NOTICE OF EXHIBITION OF SECTION 75W MODIFICATION AND STATE SIGNIFICANT APPLICATION FOR A STUDENT ACCOMMODATION BUILDING, PEMULWUY, 77-123 EVELEIGH ST, REDFERN MP06_0101 MOD 2 & SSD 8135

Thank you for the invitation dated 12 September 2017 for the Heritage Council of NSW to make a submission for the exhibition of a section 75W Modification and State Significant Application for a Student Accommodation Building, Pemulwuy, Nos 77-123 Eveleigh St, Redfern, MP06_0101 Mod 2 & SSD 8135.

Figure 36 – Photomontage (View E) showing view south along Eveleigh Street towards Redfern Station Booking Office (refer section 3.7 on page 36 for existing views). Turner architects, 2017.

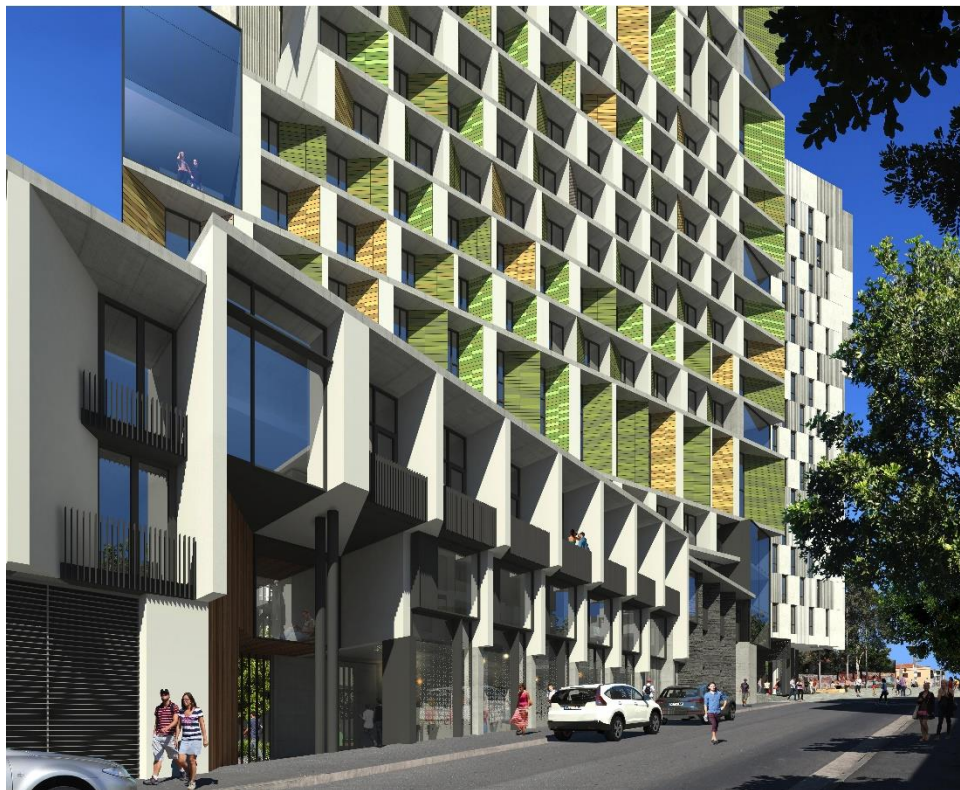
The four-fold increase in height being sought under MOD 2 will have a major adverse visual impact on Redfern Station's setting, being sited only 50m away. The proposed 24 storey tower will be an extremely conspicuous and detrimental addition to the station's immediate setting. The disparate scale between the single storey station and 24 storey tower will cause the tower to loom over the station. Also, the proposed tower will be extremely conspicuous in views to and from the front (Lawson Street) entry of the single storey Redfern Station Booking Office and in views of it along Lawson St. I acknowledge that there are four existing towers approximately 80m east of the station. However, these towers are not directly in front of the Booking Office's street elevation and are lower than 24 stories.

In addition, the tower's eye-catching combination of tall blade walls, textured finishes, strong colours, gridded fenestration and shafts of curtain glazing will draw excessive attention to itself and make the 24-storey tower appear nearer to the station than it actually is.

Because of the serious adverse impacts of the proposed 24 storey tower on the Redfern Railway Station group (SHR 01234) setting, Modification 2 should not be approved. Instead, the original six storey

concept proposal would be a more sympathetic development and it will not have an adverse impact on the setting of the Redfern Railway Station group (SHR 01234).
